Ribble Valley Borough Council
Housing & Development Control

Application no: **3/2020/0292**

Address: **52 Fell Brow Longridge PR3 3RY**

Proposal: **Demolition of existing garage and replacement with two storey extension comprising garage with first floor dormer over. Front dormer extension within existing roof.**

PROPOSED SITE & FLOOR PLANS

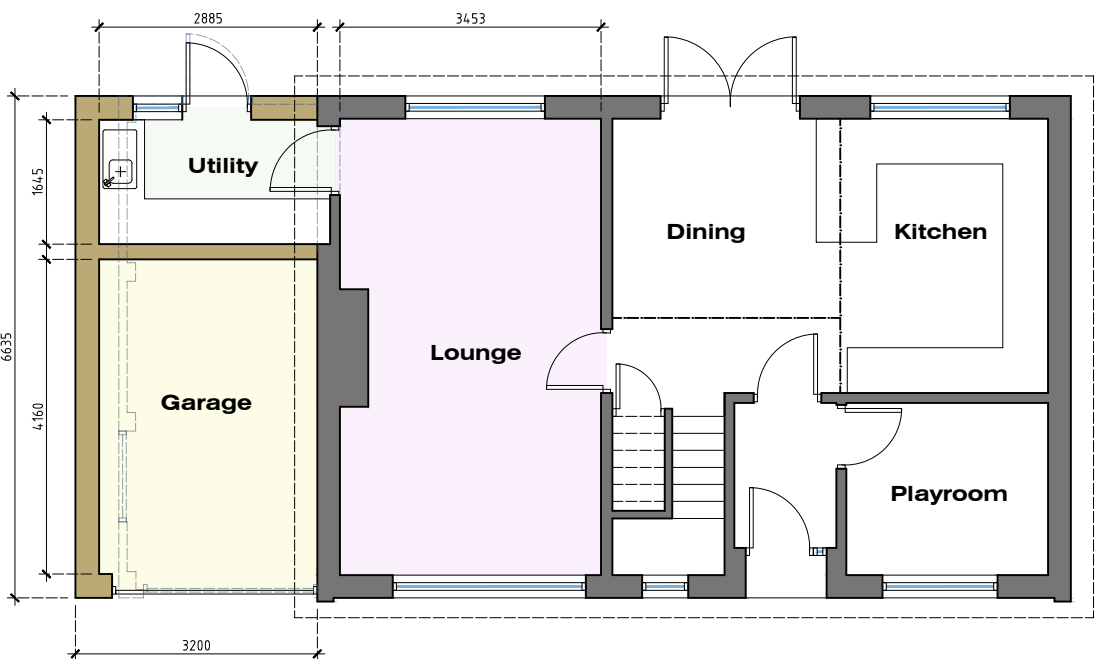
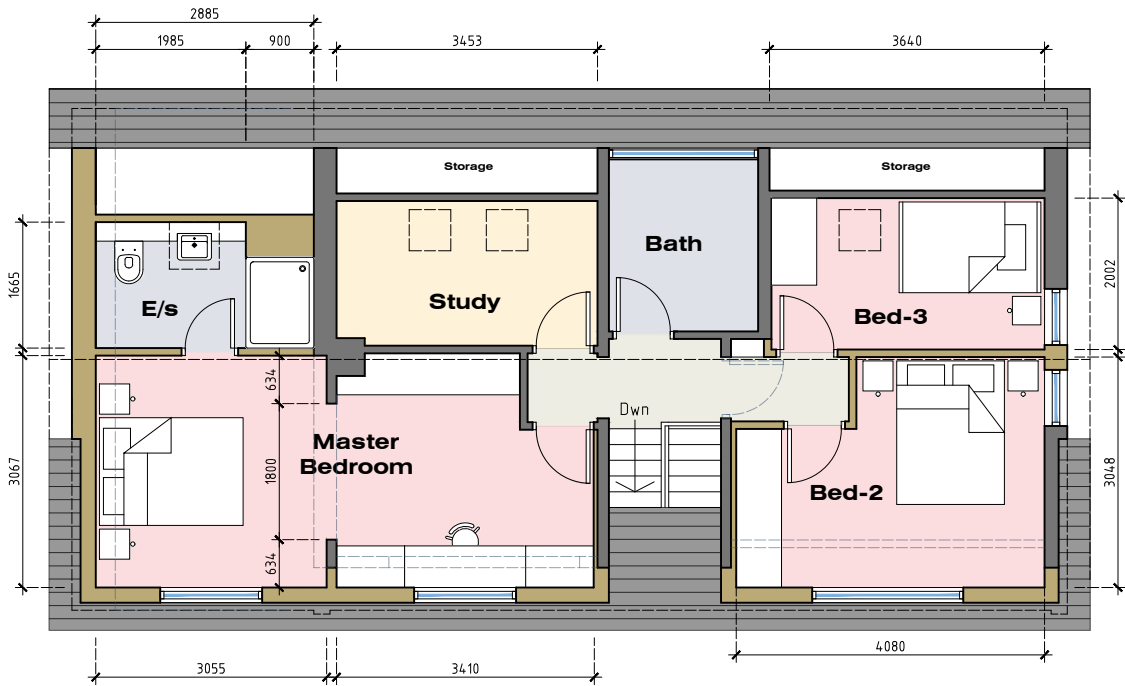
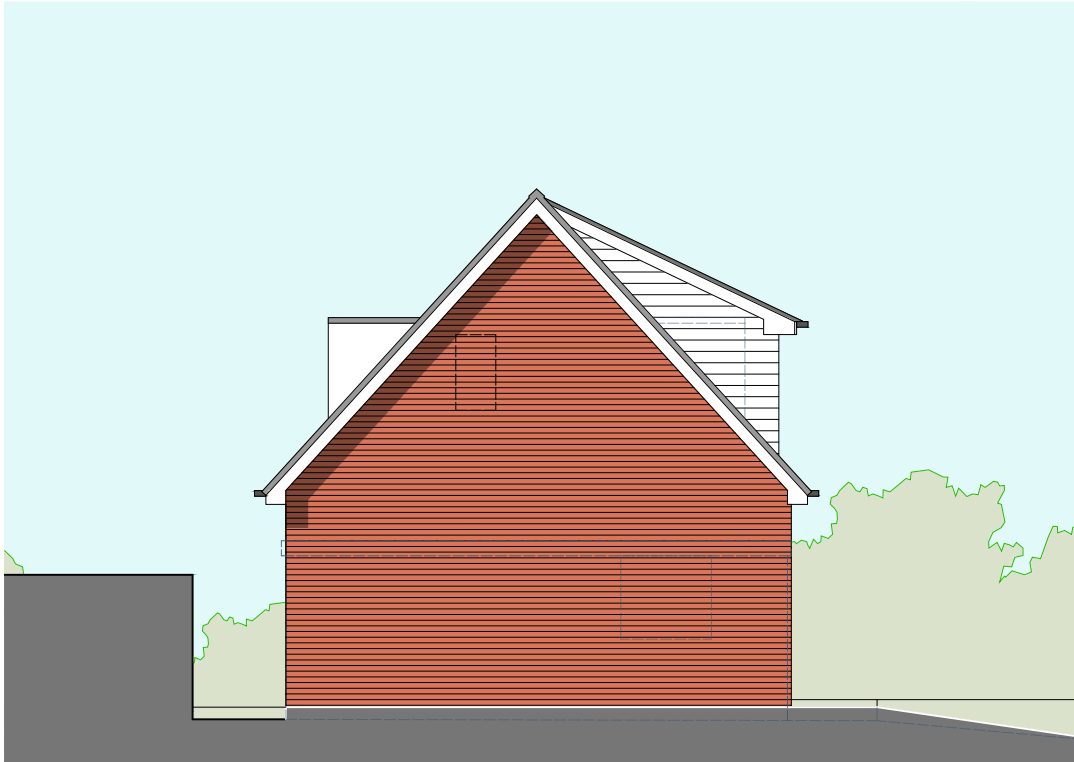
The proposal will result in the demolition and replacement of an existing garage as well as extensions and alterations being made to the existing dwelling and whilst the existing garage is to be replaced with a wider garage, the length of the proposed garage would be considered insufficient as a parking space due to the introduction of a utility room. However, as a result of the proposal the parking provision is to be retained at two parking spaces and the existing "raised rockery" area fronting the dwelling is proposed to be taken down to provide additional parking and therefore, given the extended driveway is bound with a permeable surface material I would be satisfied the proposal can accommodate two parking space within the curtilage of the property.

I would raise no objection to the proposal on highway grounds.
